June 3, 2021

Re: Responses to the following comments, EA Number EA1881, File Number AL2014:

- **Master Plan V2 Redlines, 11/25/2020, PCD Project Manager:**

FIGURE 2 - Reclamation Plan Map with HEC-RAS Cross Sections

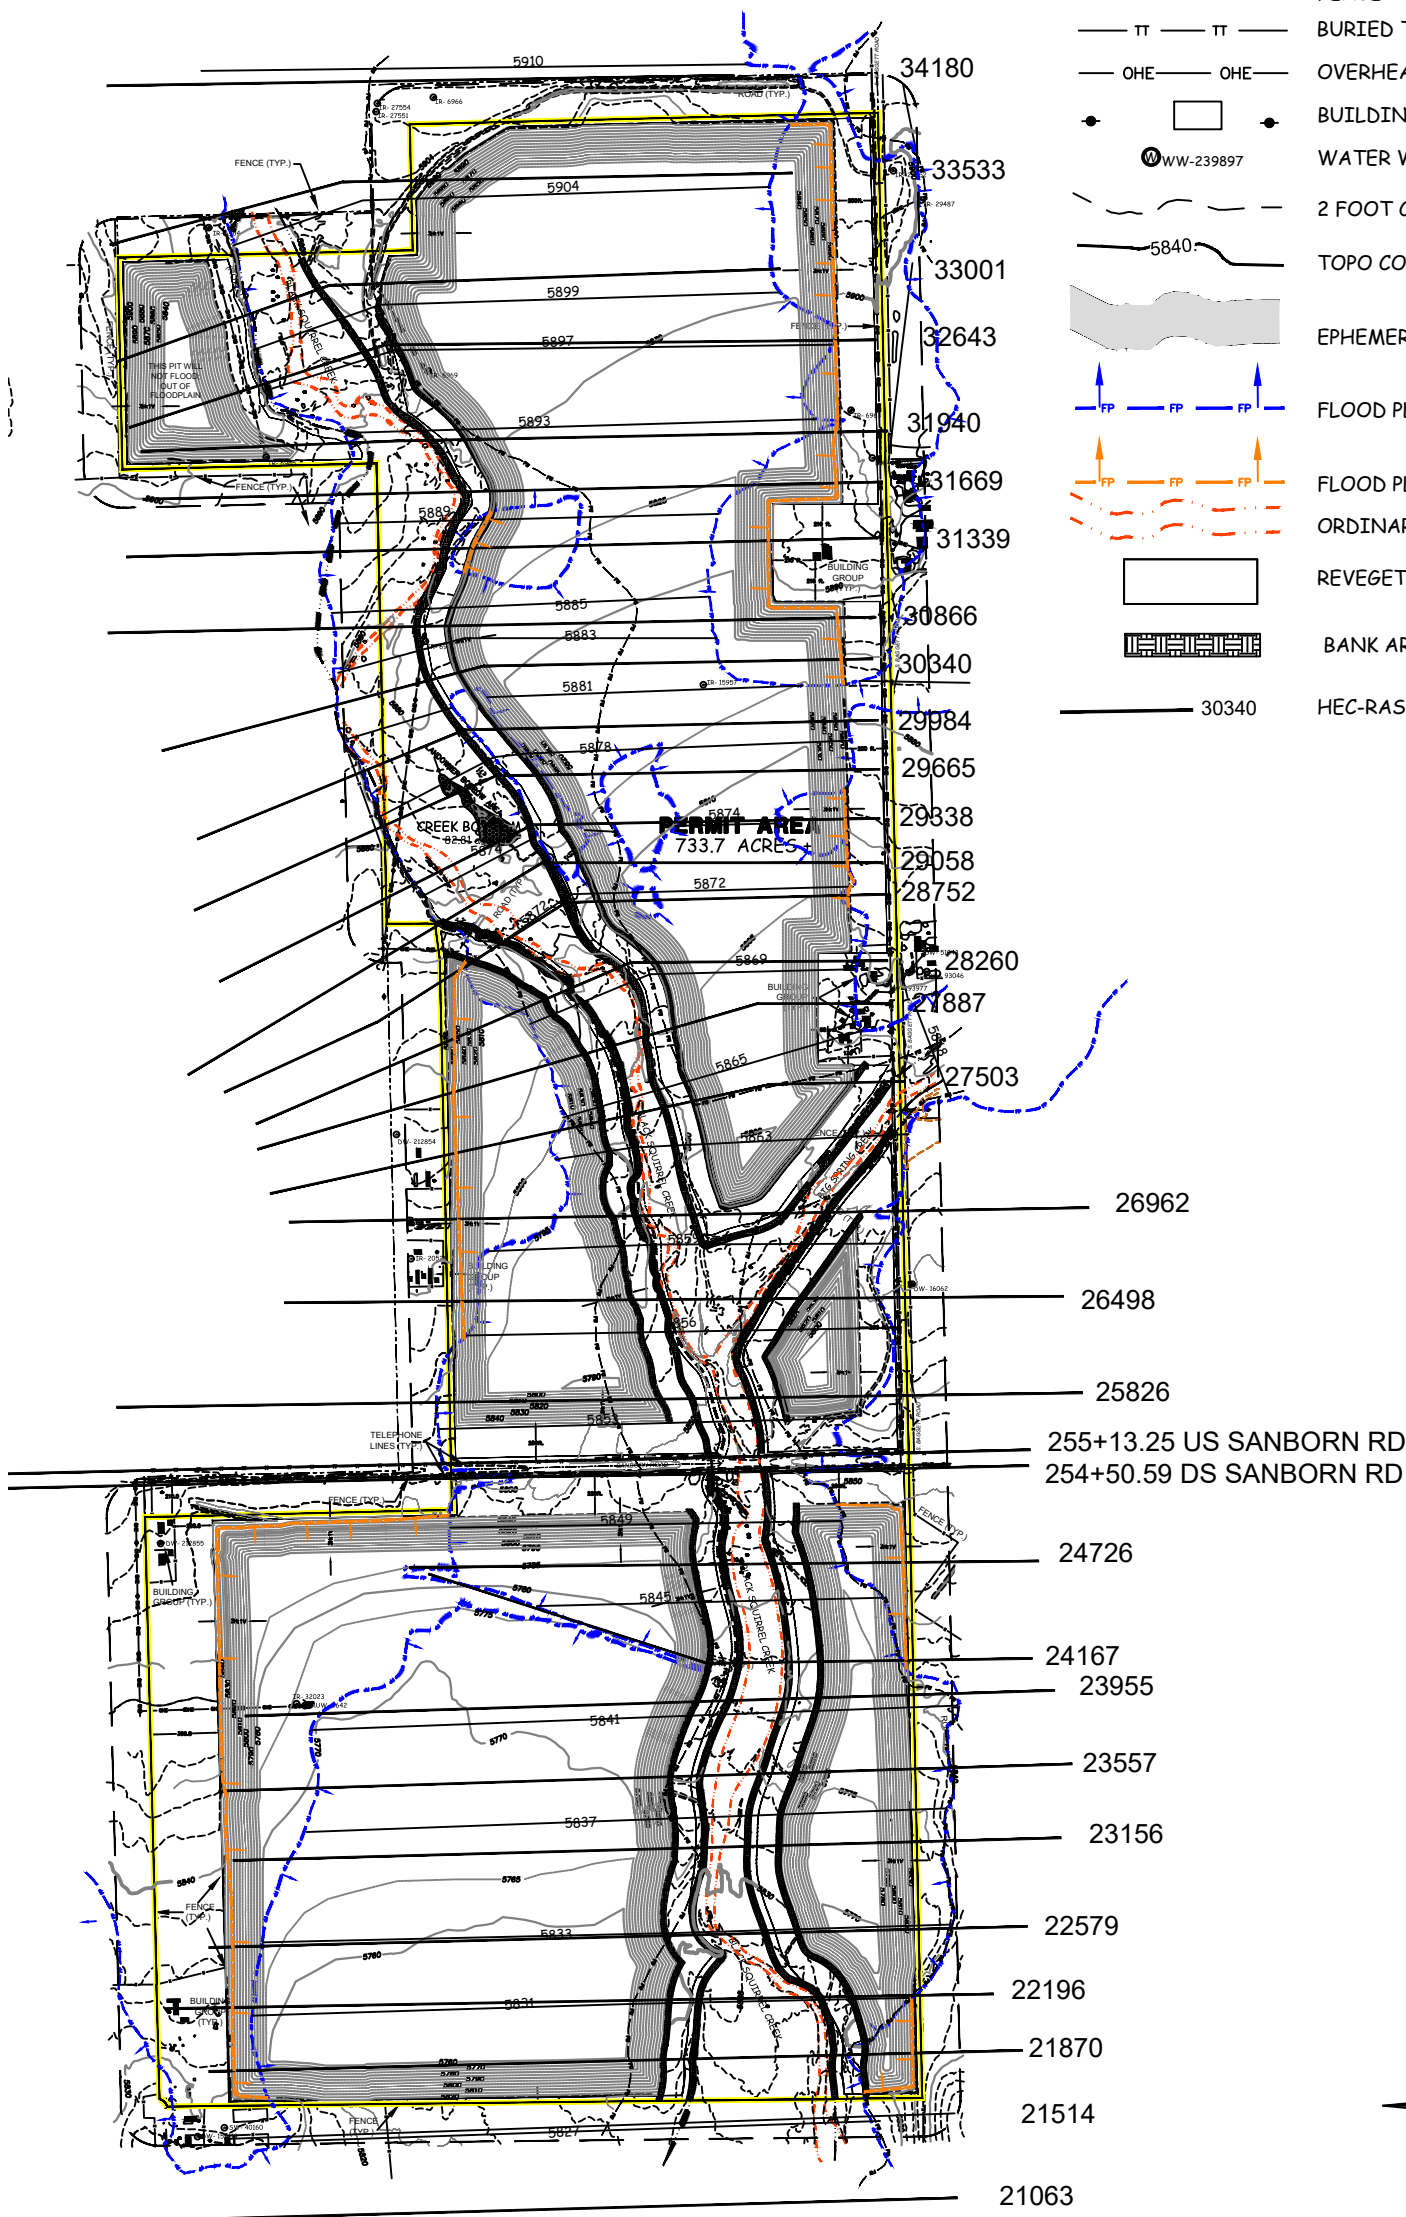
- *“Please also include goals and policies from the policy plan and water master plan. After providing the goals and policies please provide justification for how you (will) meet them*

- ❖ *“Proposed action 2.3 Proposed operations should be designed so that structure, machinery, equipment storage and repair areas, utility lines, access roads, and stockpiles are not located in visually sensitive areas such as ridges, hilltops and scenic areas. Naturalistic screening, berming and/or landscaping should be employed where natural topography will not effectively screen the operation. Facilities which may be visible should be sensitive to the natural color, form and texture of surrounding areas.”*
- ❖ Response:

- For most of the operation, mineral extraction operations will be located below the level of the natural topography.
 - Topsoil stockpiles will be located between the operation and neighboring residents.
 - As stated above, there will be a 200 foot+ separation between the various Stages (affected area) of mining operation and adjoining property owners.
 - No more than 40 acres will be open at any one time within a Stage. Once a Stage is completed, the Stage will be reclaimed. If a Stage is more than 40 acres, then affected 40 acres will begin reclamation, provided the 40-acre area is not needed for operational purposes. For example, as the most recent 40-acre area begins reclamation, the next 40-acre area will begin mining operations.

- For most of the operation and the majority of the life of the operation, mineral extraction operations will be located below the level of the natural topography.
- Topsoil stockpiles will be located between the operation and neighboring residents.

- As stated above, there will be a 200 foot+ separation between the various Stages (affected area) of mining operation and adjoining property owners.
 - No more than 40 acres will be open at any one time within a Stage. Once a Stage is completed, the Stage will be reclaimed. If a Stage is more than 40 acres, then the affected 40 acres will begin reclamation, provided the 40-acre area is not needed for operational purposes. For example, as the most recent 40-acre area begins reclamation, the next 40-acre area will begin mining operations.
